H23-0313-25 - Land At Peartree Hill Road Whaplode Drove Spalding PE12 0SL

Provision of new poultry unit & associated works

Summary: I wish to submit a holding objection on this application due to the lack of ecological impact information supplied by the applicants (described below).

Drawing file: H23-0313-25 / App6 BNG Post Development Habitat Map.pdf

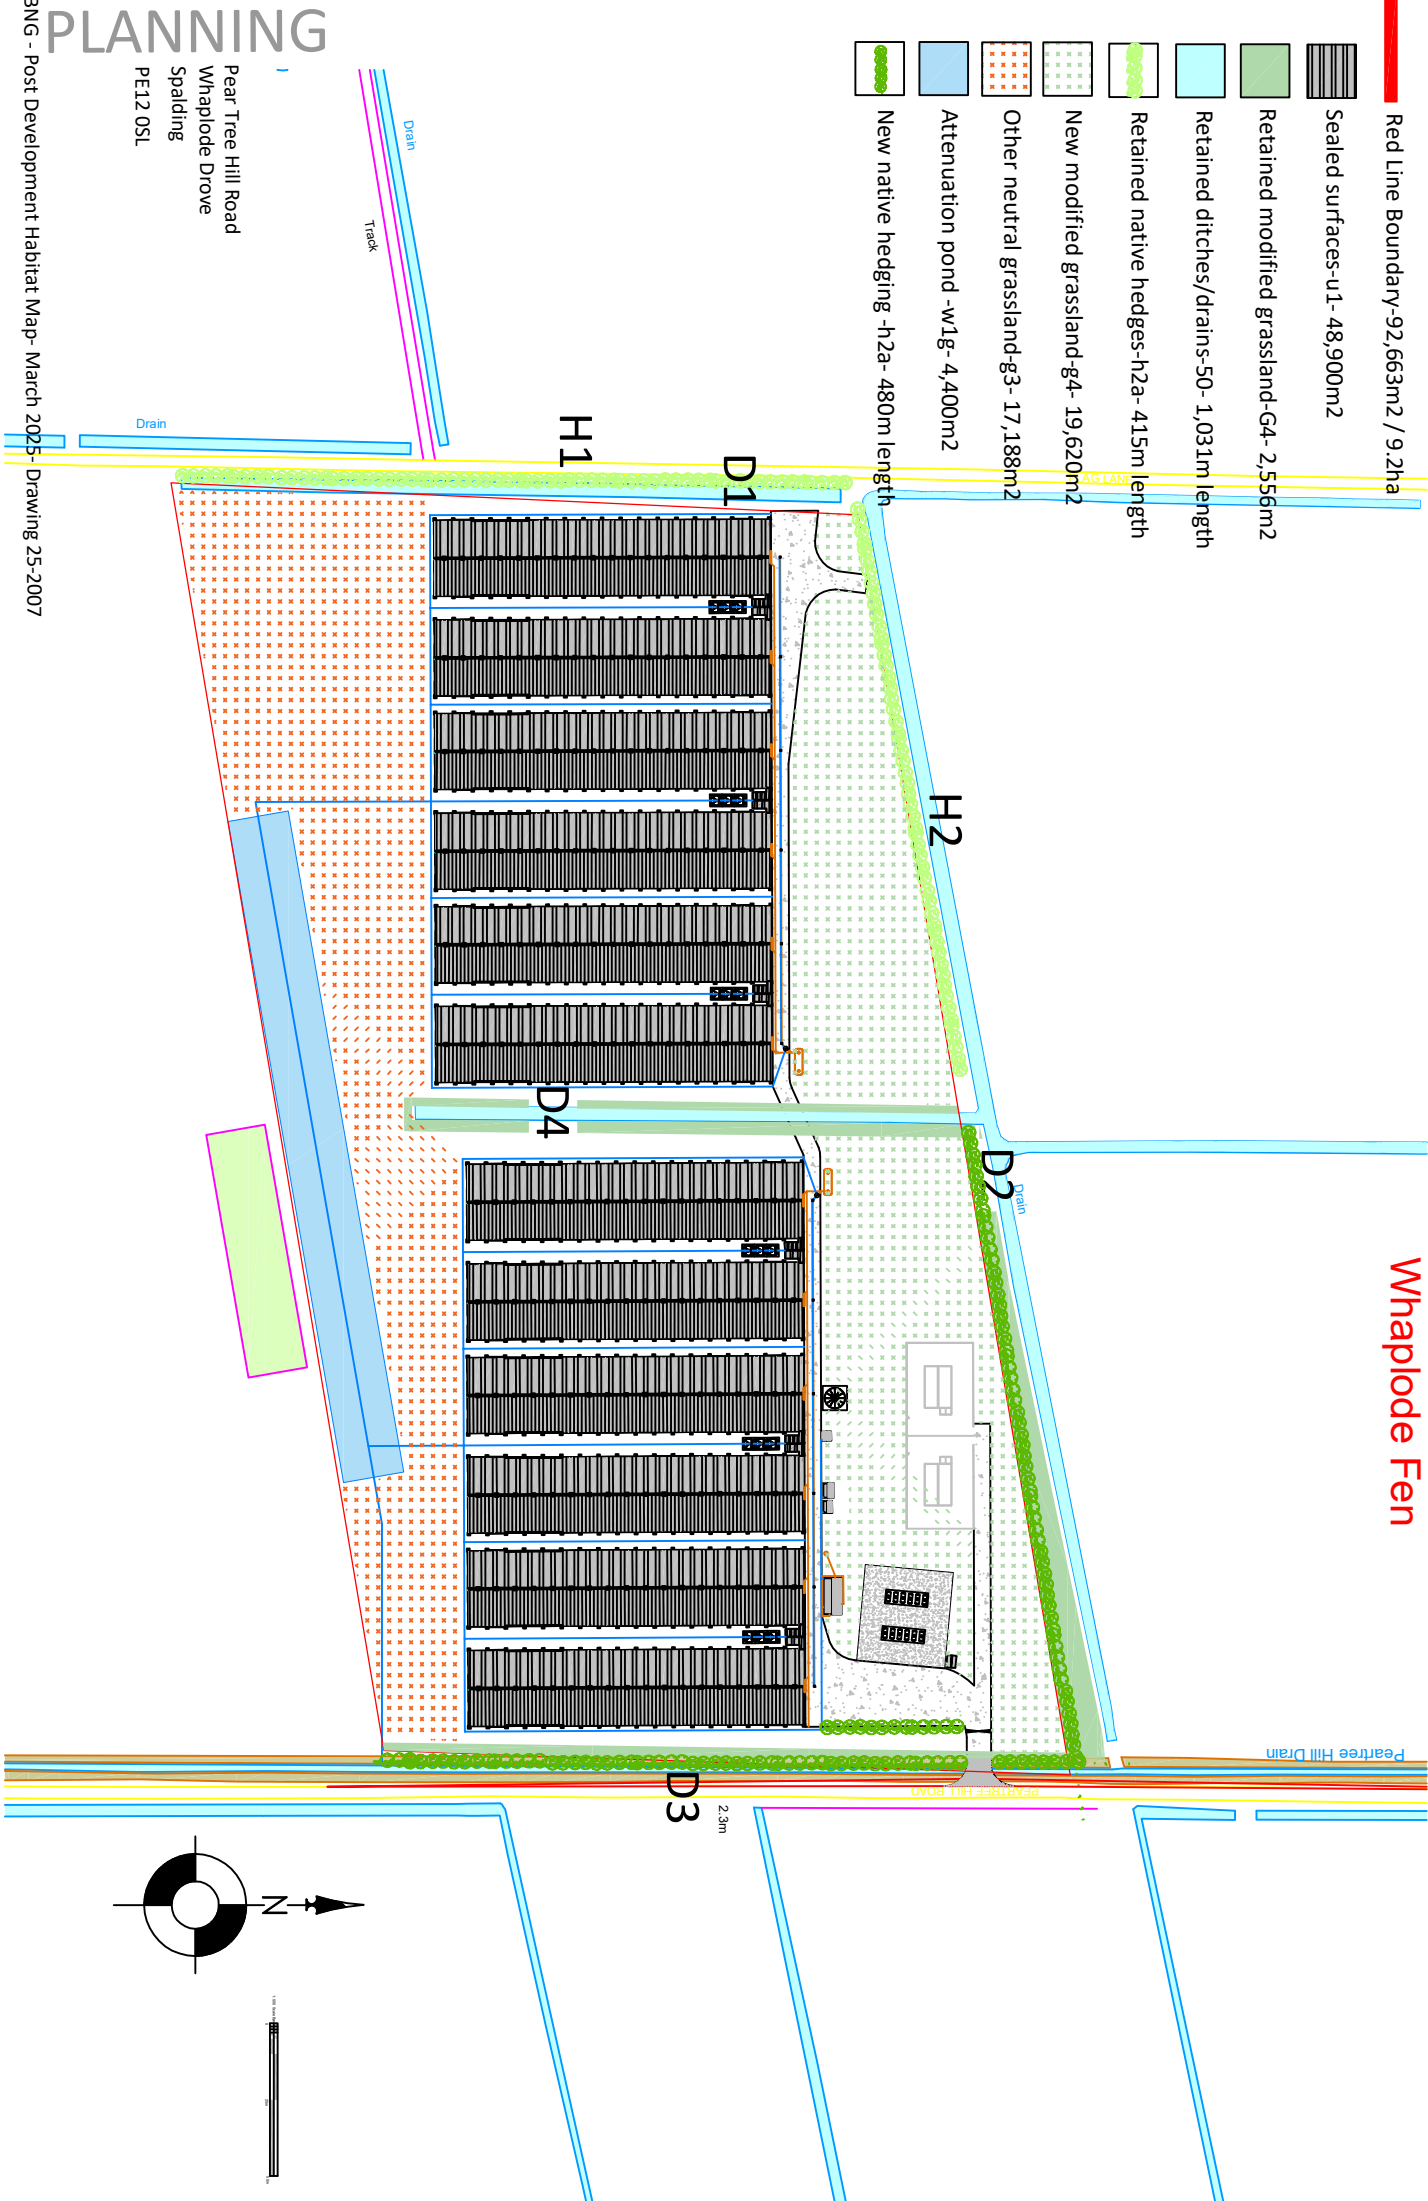
- The BNG assessment achieves sufficient rigour and accuracy such that the authority can be confident in the baseline biodiversity value estimates for the development site. However, the authority cannot be confident that the development will achieve 10% BNG on-site as currently estimated, because the proposed post-development area-habitat condition targets are likely unrealistic (as described below). Upon amending the metric to reflect more feasibly attained habitat targets, we estimate that the development will likely need to secure approximately 1.64 habitat units off-site to achieve 10% BNG.

- The post-development habitat condition targets have been recorded as “good” for the proposed creation of “modified grassland” and “other neutral grassland” habitats immediately adjacent to the north and south of the poultry barns respectively. However, there is an unacceptably high risk that these condition targets will not be met due to the negative impacts on these habitats from high levels of nitrogen oxide (NO_x), nitrogen (N), and ammonia (NH₃) deposition arising from the adjacent poultry sheds. NO_x and concentrated NH₃ act as environmental pollutants that damage broad-leaf plant cells, inhibit growth, and make plants more vulnerable to stressors such as drought or pathogens. In addition, they contribute to terrestrial eutrophication whereby fast-growing grasses adapted to high nutrient/Nitrogen levels will outcompete the large majority of herbaceous grassland plants adapted to low-nutrient conditions, thereby cumulatively reducing the high species diversity required to achieve “good” condition grasslands.

- To quantify the impacts above, we used the “Simple Calculation of Atmospheric Limits (SCAIL)” to model NH₃, N, and Acid deposition rates on the neutral grassland within 100m of the centroid of the barns (the same modelling method used by the applicants to assess the impacts on Cowbit Wash SSSI). The model results estimated that the critical loads for both NH₃ and N will be exceeded = 473% of lower threshold and 158% of upper threshold for NH₃, and 312% of threshold for N. Exceedance of critical load thresholds broadly indicates that harmful and adverse effects will occur over the long term (e.g., the 30 year BNG period), and therefore, there is a very high likelihood that the proposed grassland habitats will remain degraded and fail to retain the required vigour and diversity required to qualify as “good” condition grassland habitat.

Conclusion: We argue that there is an unacceptably high risk of not achieving the desired biodiversity outcomes and the development consequently failing to achieve the mandatory 10% BNG than if a lower, more easily achieved habitat condition score was used in the metric, which would provide some buffer against this risk of failure. Therefore, we do not support the current metric assessment and ask the applicants to resubmit an amended metric that records the post-development modified grassland and other neutral grassland in “moderate” condition. Upon amending the metric to reflect more realistic habitat targets, we estimate that the development will likely need to secure approximately 1.64 habitat units off-site to achieve 10% BNG. However, there may be other viable alternatives for on-site habitat creation that the applicants could explore with expert ecological advice.
